Your Ref: SSI 6878  
Our Ref: DE-2015/16  
Date: 9 December 2015

**Albion Park Rail Bypass State Significant Infrastructure Proposal (SSI 6878)**

## **Attachment A Comments to the Environmental Impact Statement**

Figure 6-7 Interchange at Yallah

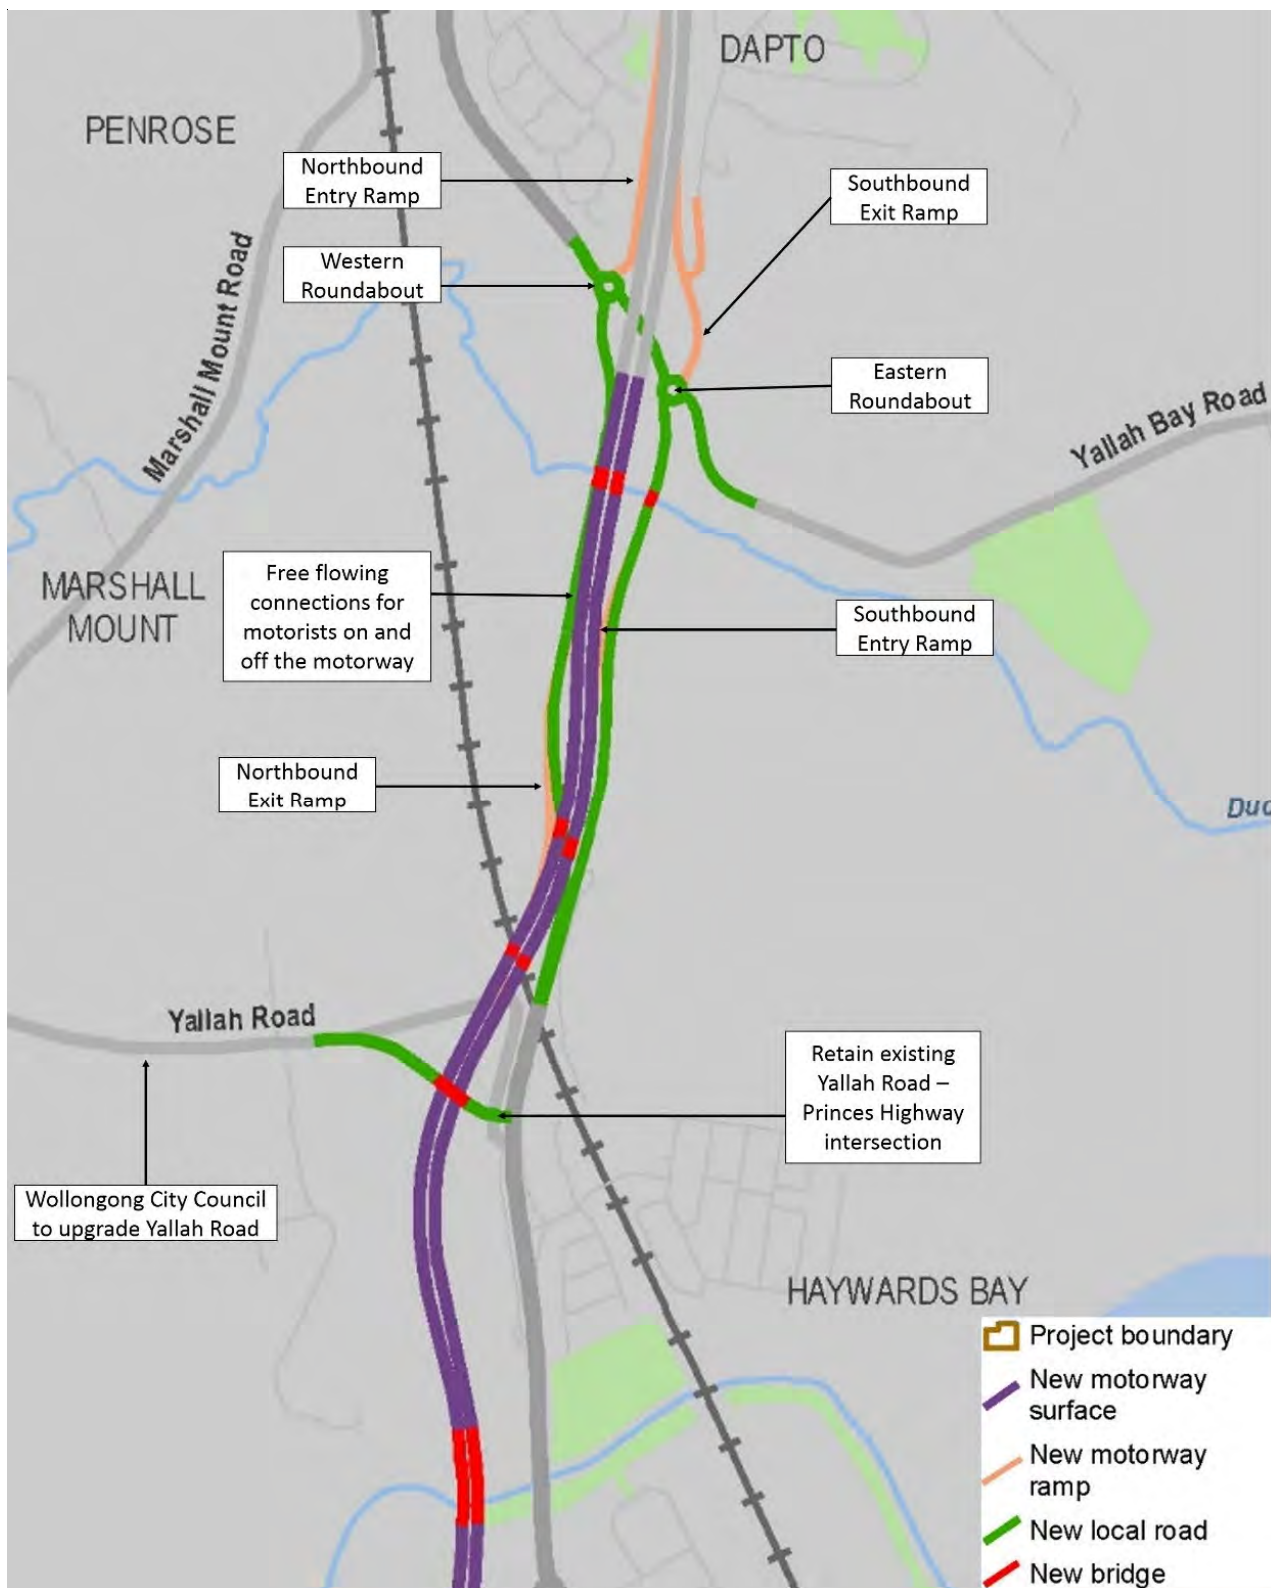
Council remains supportive of the proposed Tallawarra (Yallah) interchange, including the interim left-in/left-out at Cormack Ave. The following comments are provided based on Council's previous feedback:

- Weave issues on Princes Hwy (southbound) south of Yallah Bay Road – the technical paper considers merging sections (i.e. M1 southbound entry ramp merge), however the weave of traffic across two lanes to enter the M1 southbound off ramp appears not to have been considered. It is essential that RMS address these issues as part of the detailed design process.

- Given the unopposed eastbound traffic movement at the eastern roundabout, Council has concerns with queues/delays to the M1 southbound offload traffic at the roundabout. Whilst the technical paper Sidra analyses shows an average LOS B at 2041 PM peak, the delay at the off ramp leg is not shown. Council has also undertaken Sidra modelling of the proposed roundabout under 2036+ (ultimate) traffic demands (refer *"Princes Highway-Yallah Road Connection – Tracks Modelling Summary Sept 2015"*). The results show poor LOS and lengthy queues in the PM peak

on the southbound off-ramp. Again, it is essential that RMS address these issues as part of the detailed design process.

Figure 6-12 Albion Park Interchange

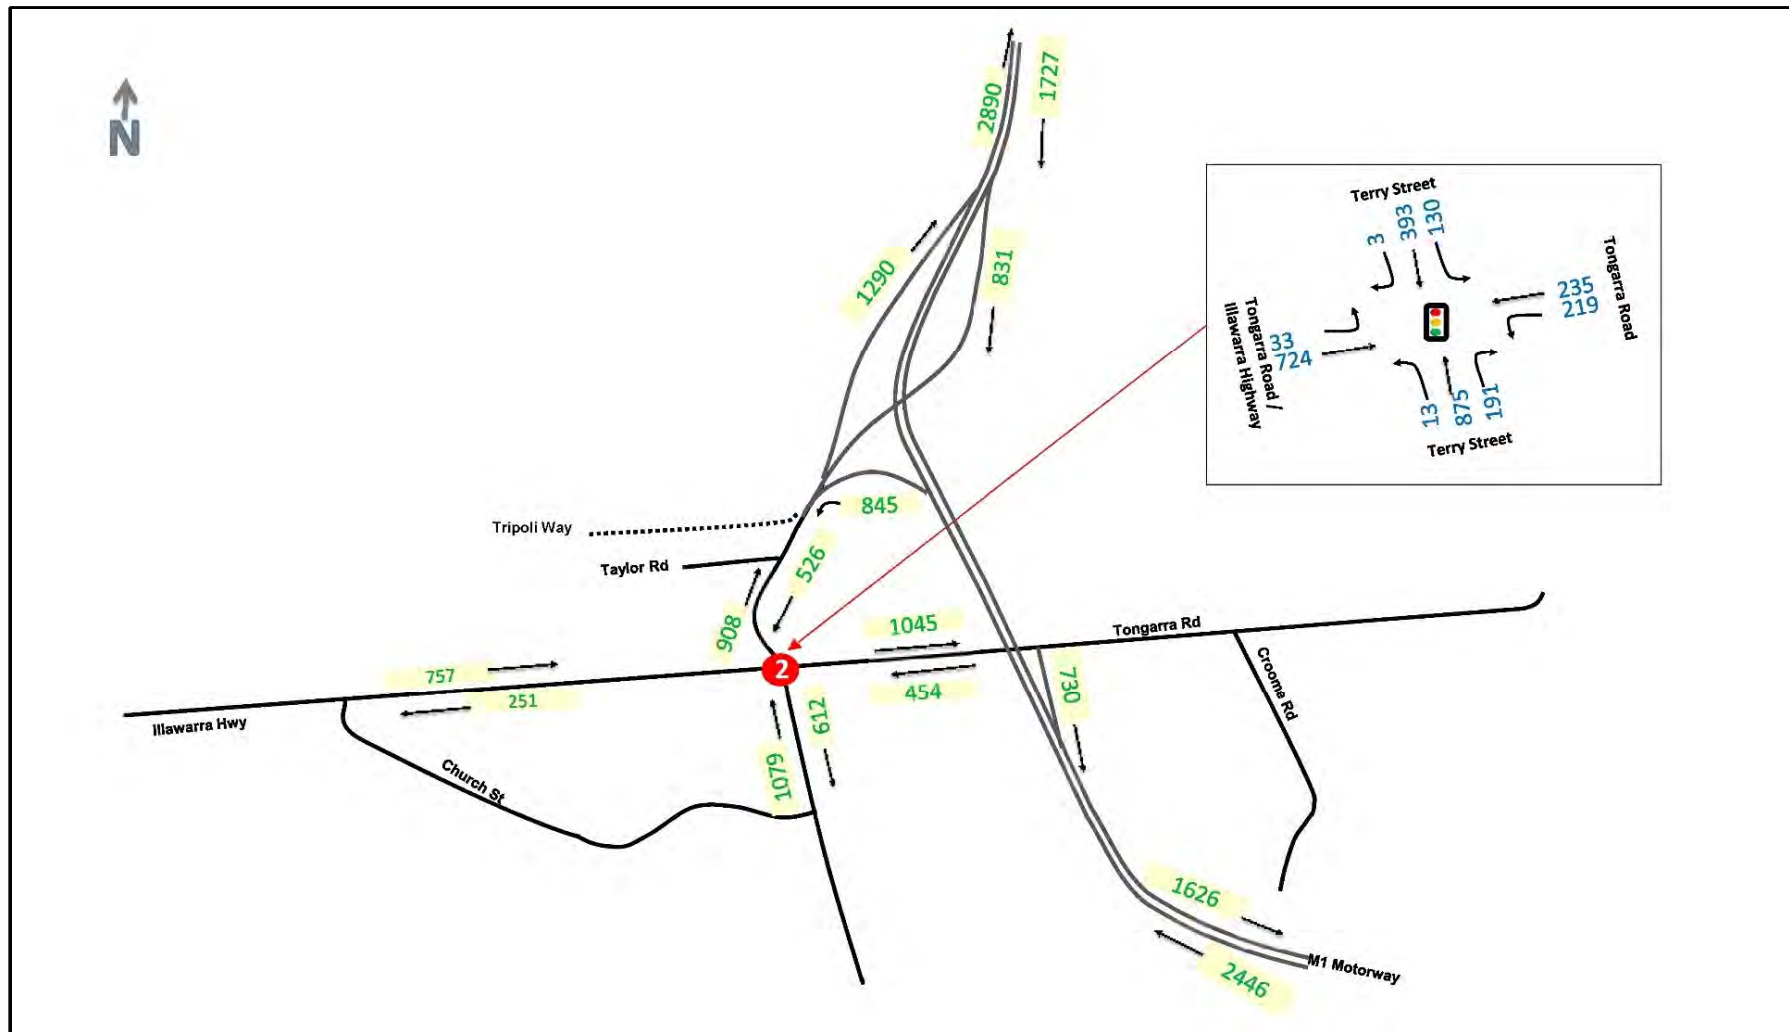
The Technical Paper 1 – Traffic & Transport (section 6.5.2.4) notes that the intersection of Tongarra Rd and Terry St will have unacceptable operation by 2020 unless the Tripoli Way upgrade is completed. The uncertain timing of the Tripoli Way extension is of concern to Council, because any increase in congestion and delays at Tongarra Rd/Terry St will further redistribute and encourage northbound traffic to short cut along Marshall Mount Rd/Yallah Rd. Any potential adverse impacts in this regard have not been identified in the EIS.

The Technical Paper tables results of intersection analysis of Tongarra Rd/Terry St intersection (with Tripoli Way extension in place), however doesn't include any analysis or commentary on the operation or proposed layout of the Tripoli Way/Terry St intersection, which is hoped to cater for the majority of traffic to/from Calderwood. Whilst Council supports the provision of the Tripoli Way connection, there are some obvious challenges with providing this intersection, for example southbound weave manoeuvres from the M1 northbound off-ramp to Tripoli Way, and possible queuing of southbound traffic due to the opposing northbound on-load traffic demand at the Tripoli Way intersection. If RMS is relying on Tripoli Way to address the substantial performance issues at Tongarra St/Terry St, then it is very important that the EIS confirms the acceptable design and operation of the new Tripoli Way/Terry St intersection. This also has ramifications for the future traffic demands on Marshall Mount Rd which is a serious concern for Council, as detailed above.

Refer to previous comments above under “Calderwood and Impacts”, regarding possible southbound weaving and queuing issues on approach to the future Tripoli Way intersection.
